From: Maria Tomalova
Sent: 19 June 2019 10:01
To: Planning.Responses
Subject: FW: FP/274/18/PL, 10 Felpham Gardens
Attachments: Prop FF Plan Unit 1.pdf; Prop Elevations Unit 1.pdf

From: Tim Rodway | Rodway Planning | [REDACTED]
Sent: 19 June 2019 07:38
To: Maria Tomalova
Subject: RE: FP/274/18/PL, 10 Felpham Gardens

From: Maria Tomalova [REDACTED]
Sent: 18 June 2019 18:56
To: Tim Rodway | [REDACTED]
Subject: RE: FP/274/18/PL, 10 Felpham Gardens

PROPOSED ELEVATIONS
UNIT 1

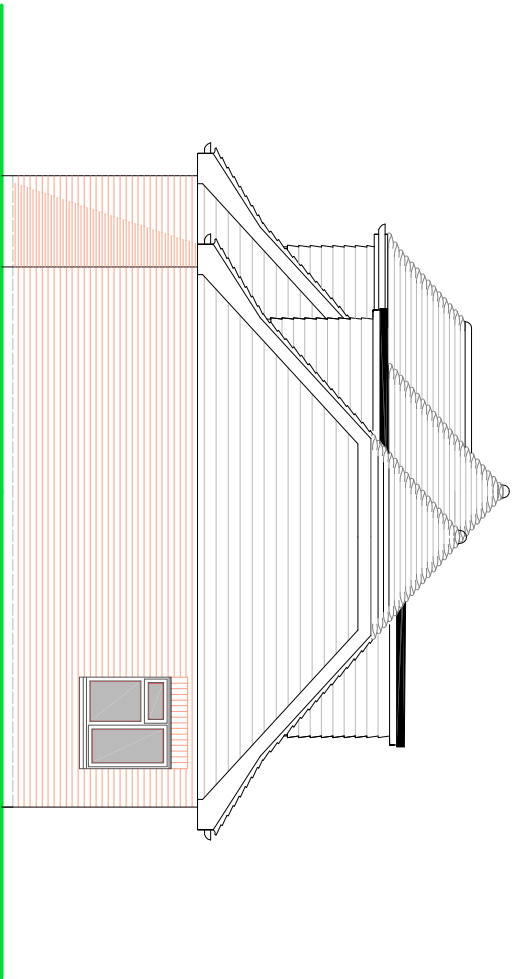
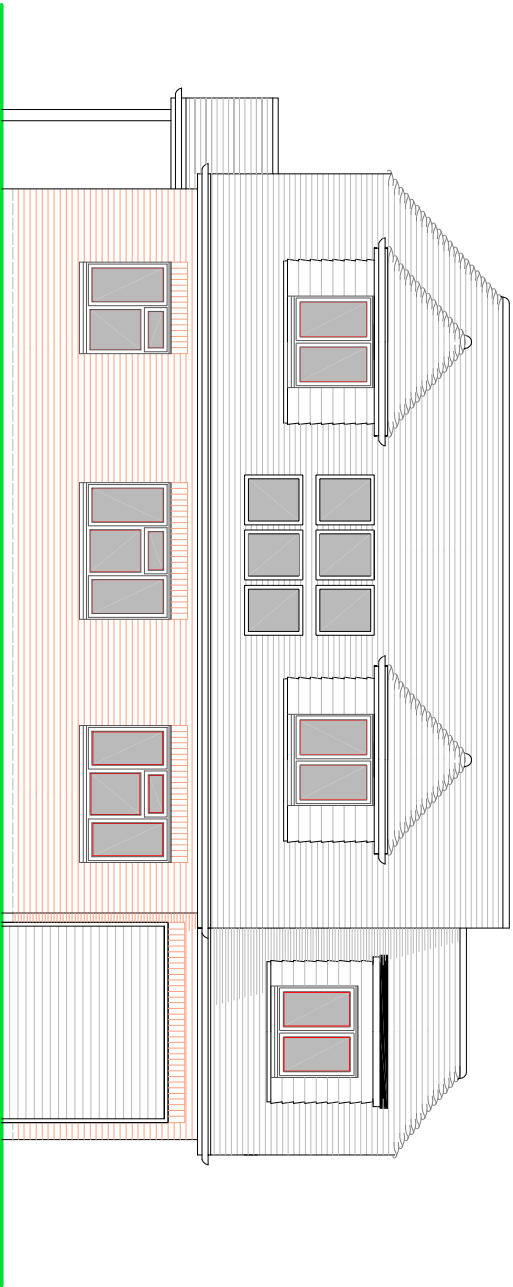
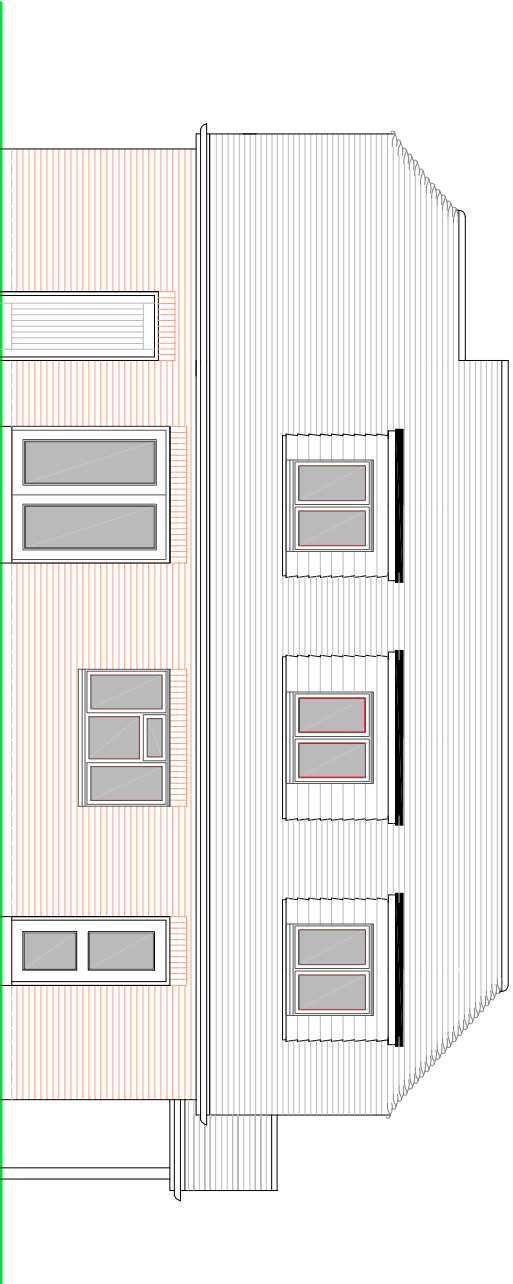
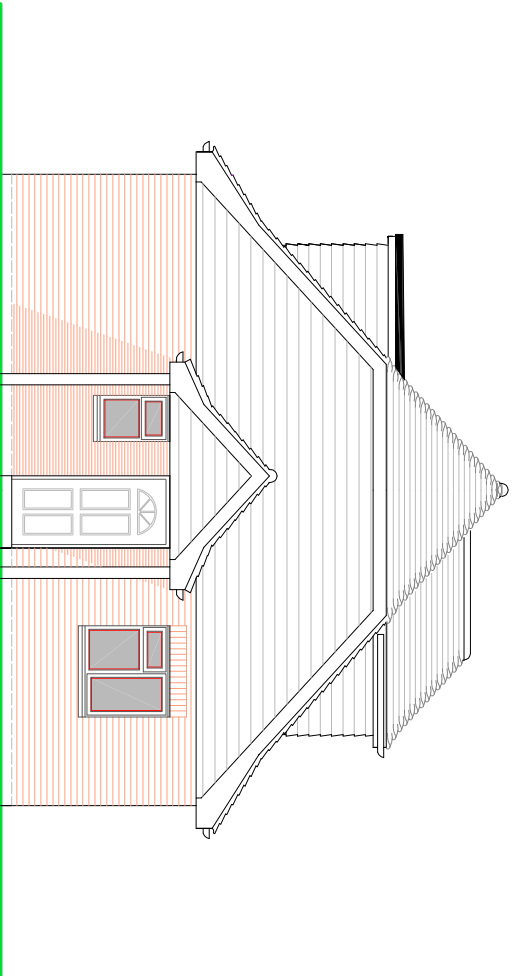
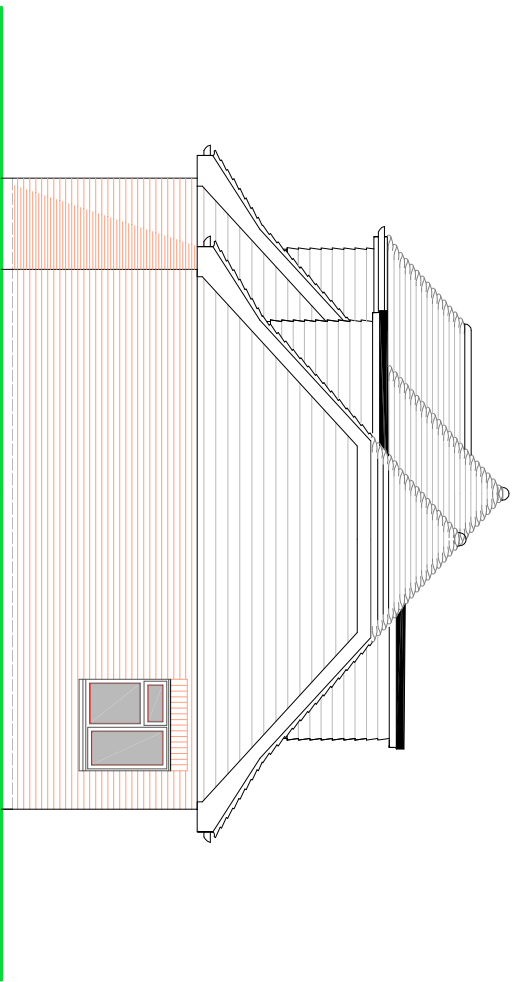
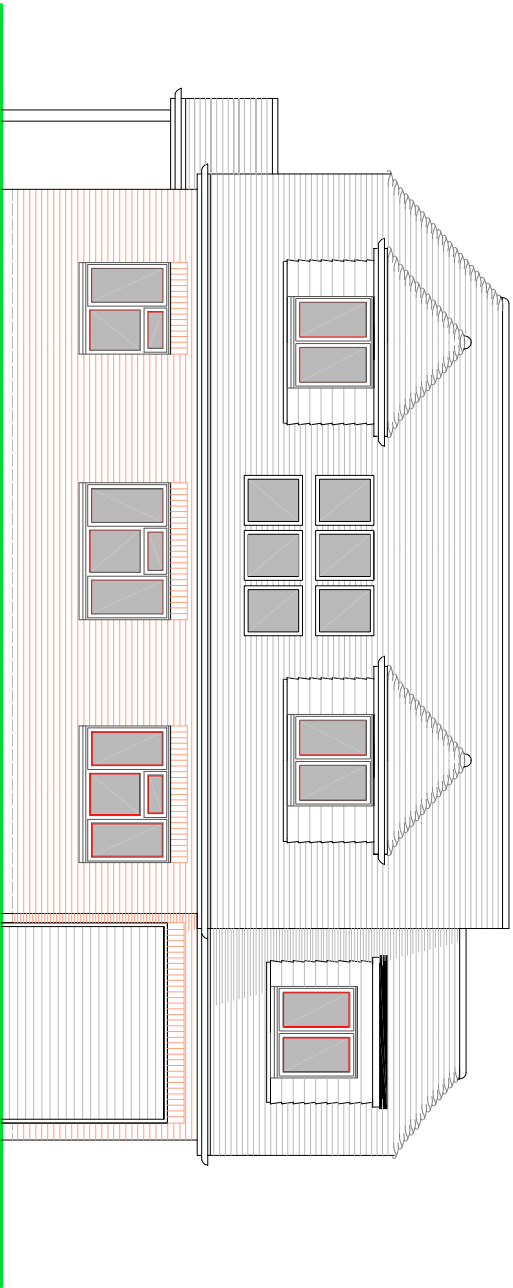
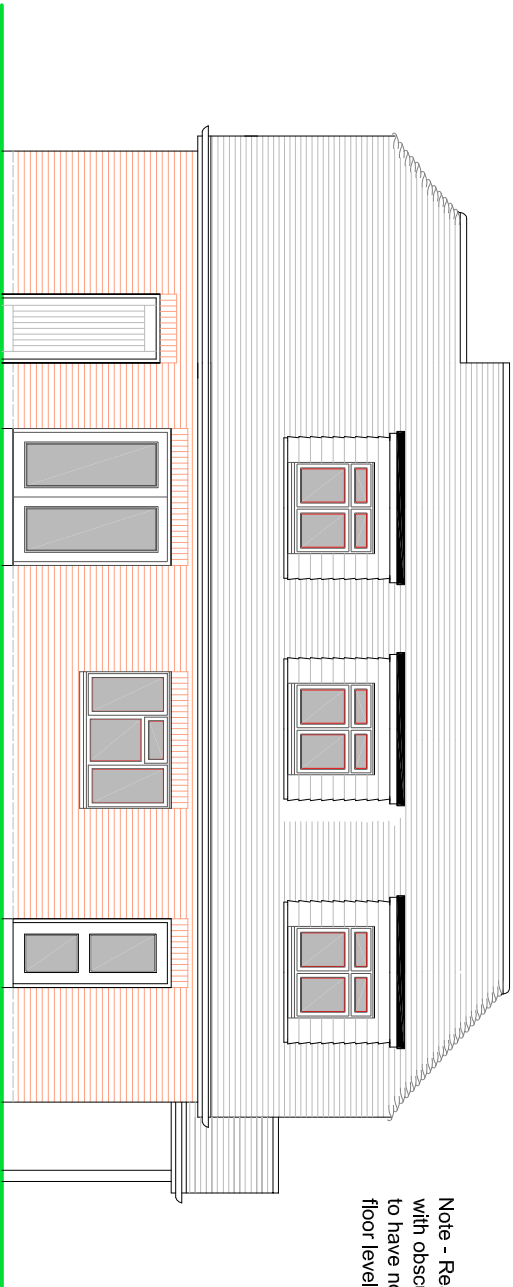
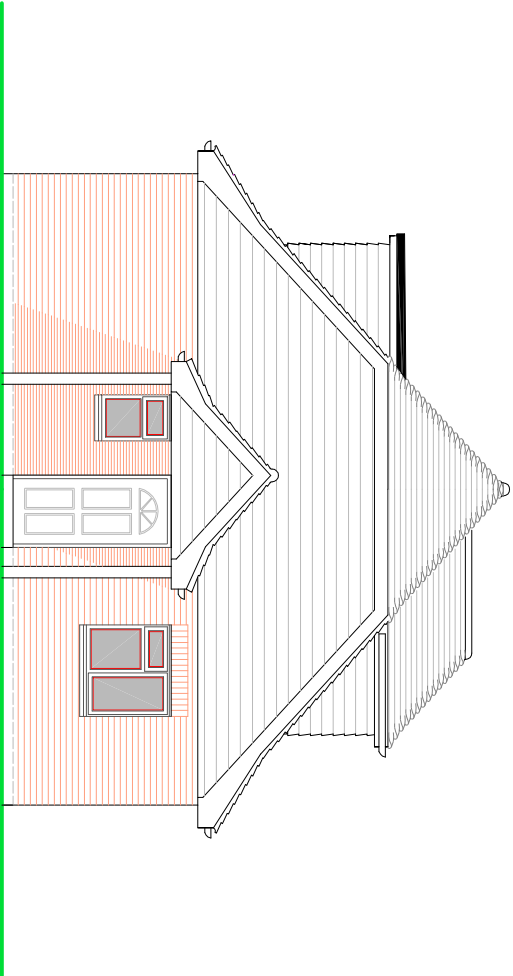
In the submitted drawings of Unit 1 , Northern Elevation the dormers window are shown openable and with a clear glass.

I would advise you to amend this drawings showing the windows of the proposed dormers non openable up to 1.7m and obscure glazed to avoid confusion.

PROPOSED ELEVATIONS
UNIT 2

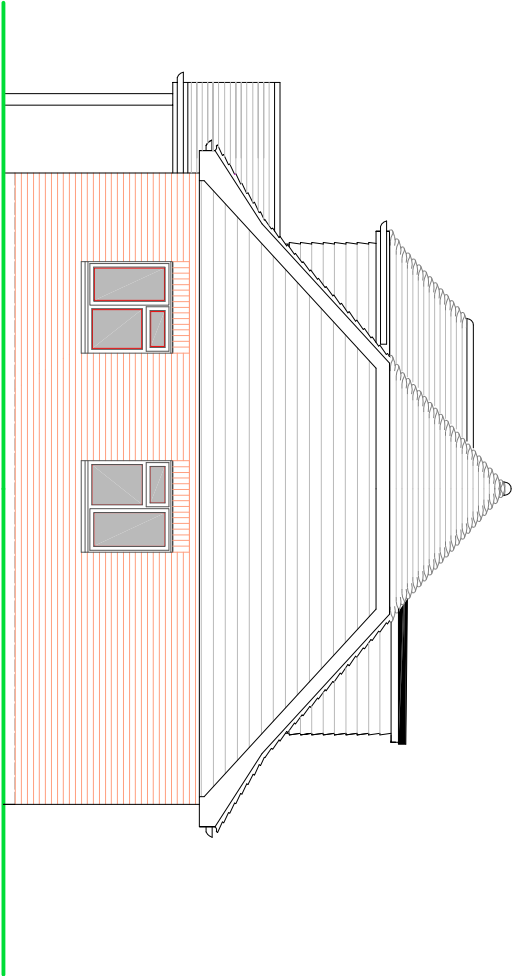
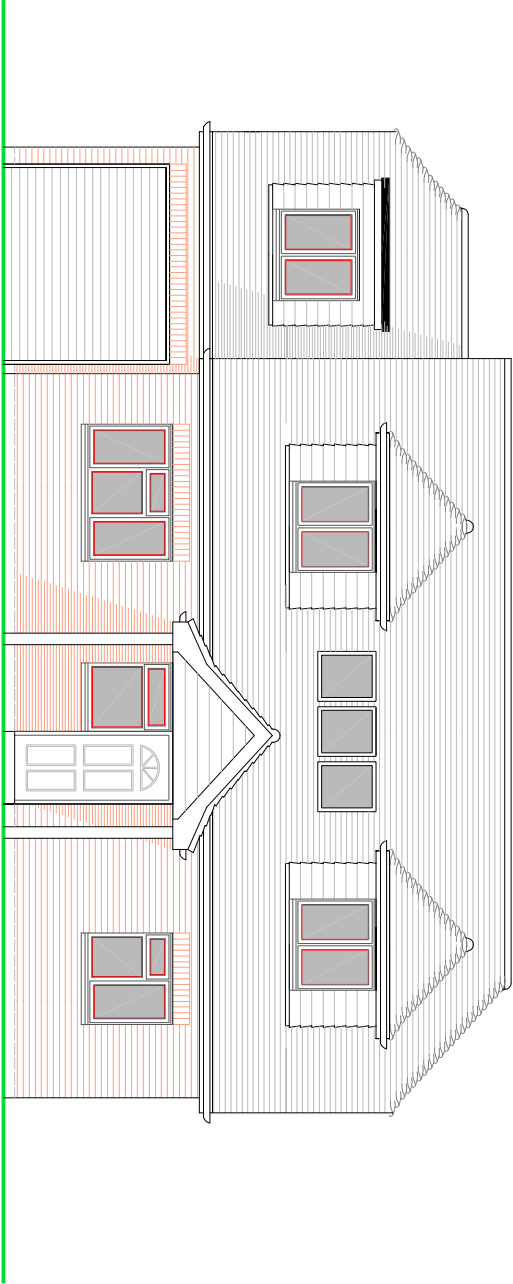
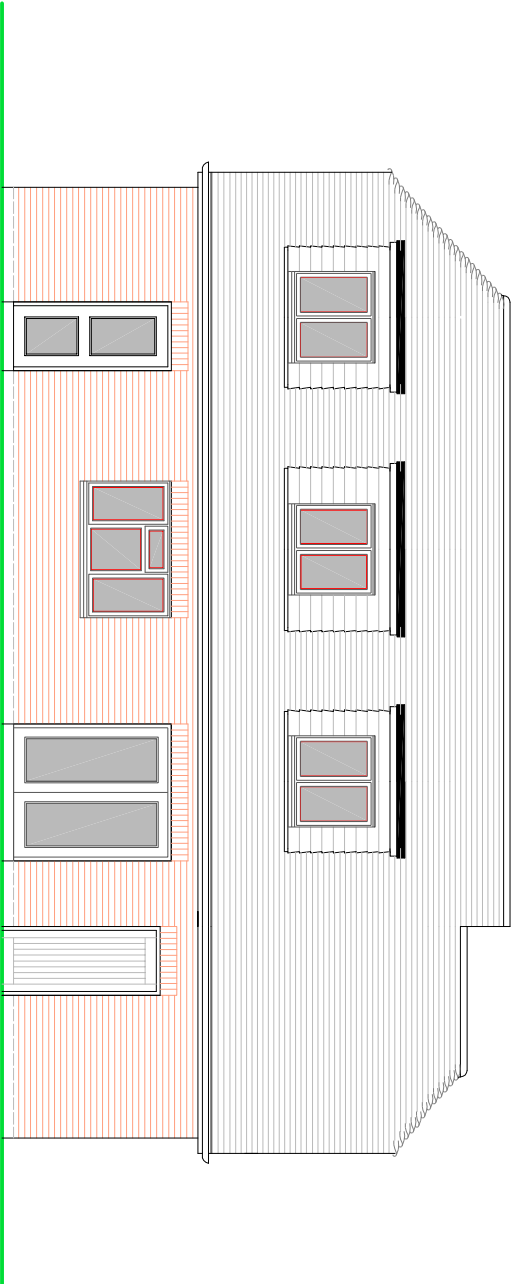
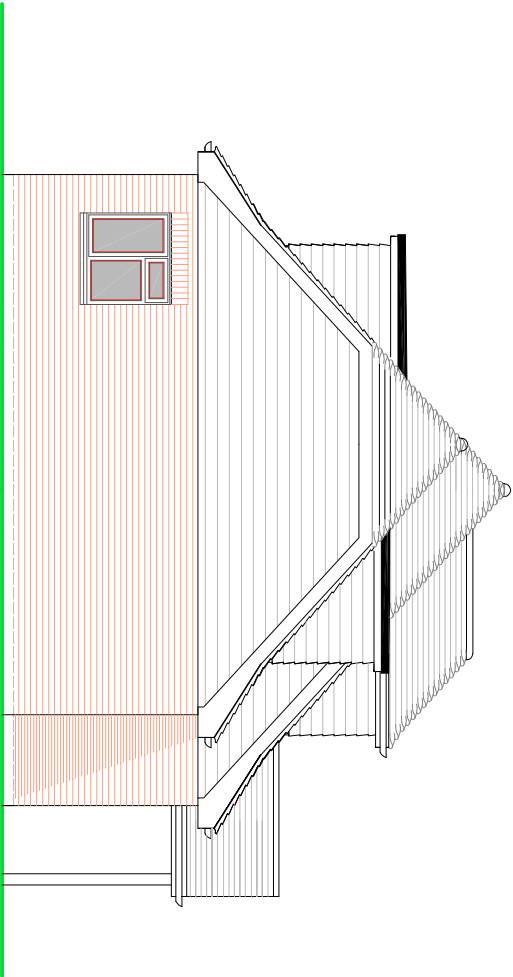
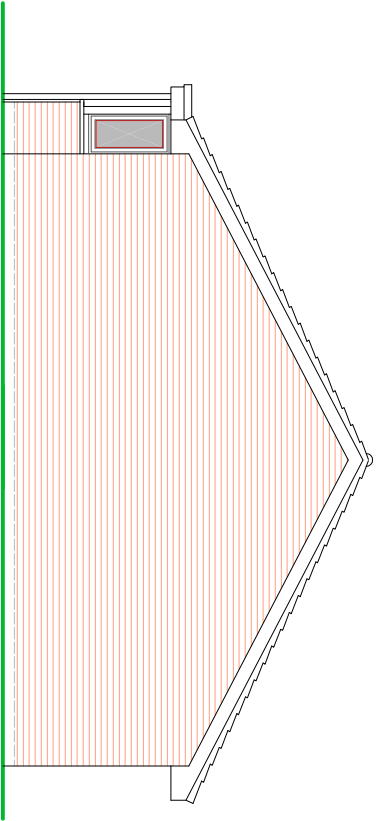
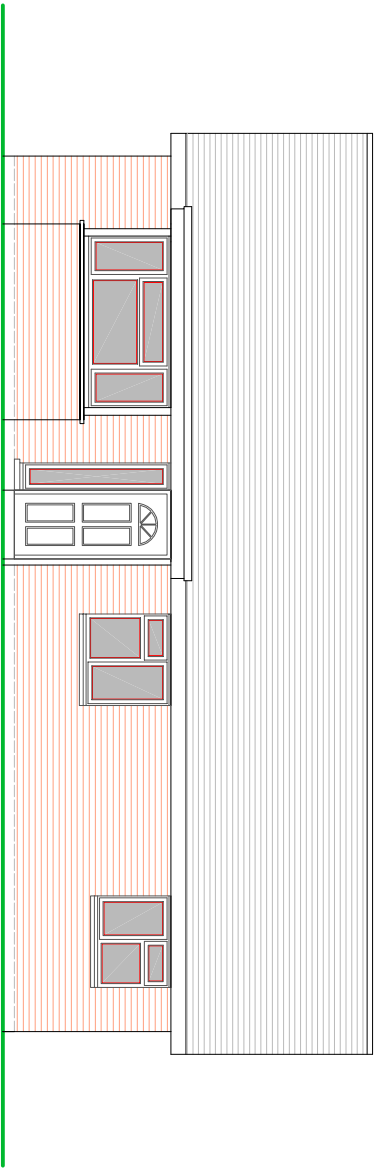
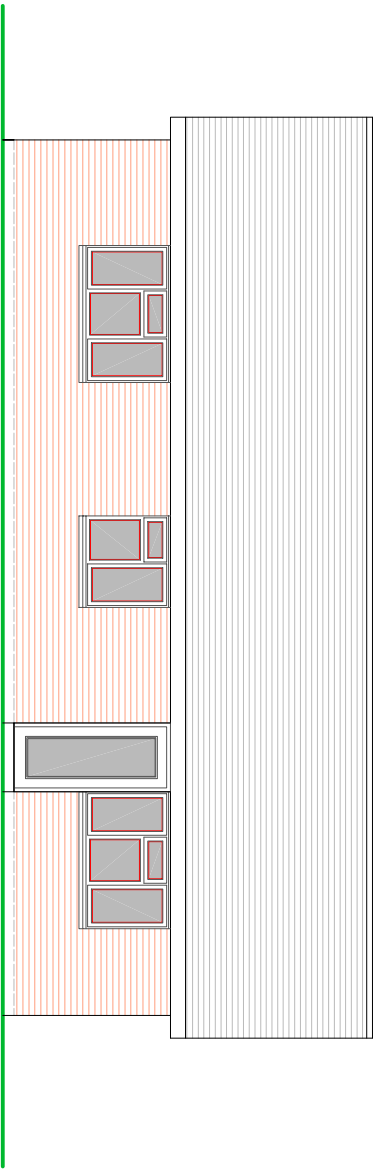
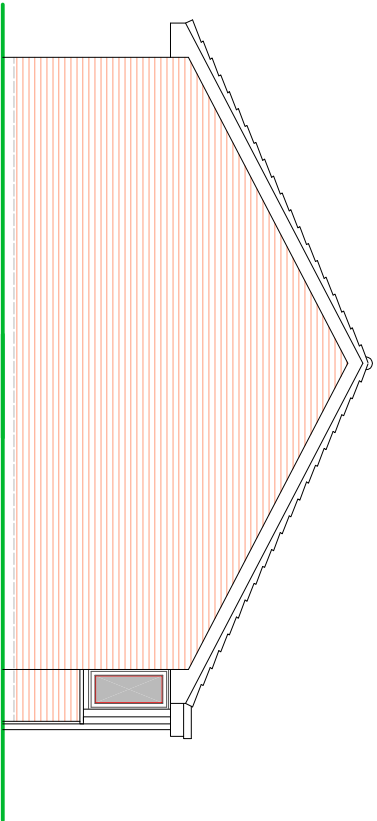
- Lower the ridge of the roof; one level in this particular case would be desirable
- Unit 1 is proposed aligned with the existing house No 8 Felpham Gardens as such it would not affect substantially the residential amenity of this property.
- However the proposed Unit 2 of the same shape and scale as Unit 1 would be obscuring the outlook from the rear of No 8 and would be an overbearing structure (12.5m deep, 6.7m high), entirely closing the view to the south and within the winter time when the sun is low, from the sun-light.
Suggestion: proposed Unit 2 should be reduced considerably (the height in the between of the proposed Unit 1 and an existing bungalows to the east) to be acceptable without affecting the amenity and prospect of inhabitants of No8
Probably you can reduce the width of Unit 2 by re-positioning the garage where the cycle storage is proposed with a direct access to it.

In summary, and in line with your advice, Unit 2 has been reduced to a single storey dwelling. Unit 2's garage has been repositioned, in line with your recommendations. We can advise that the gross internal floor area of the new
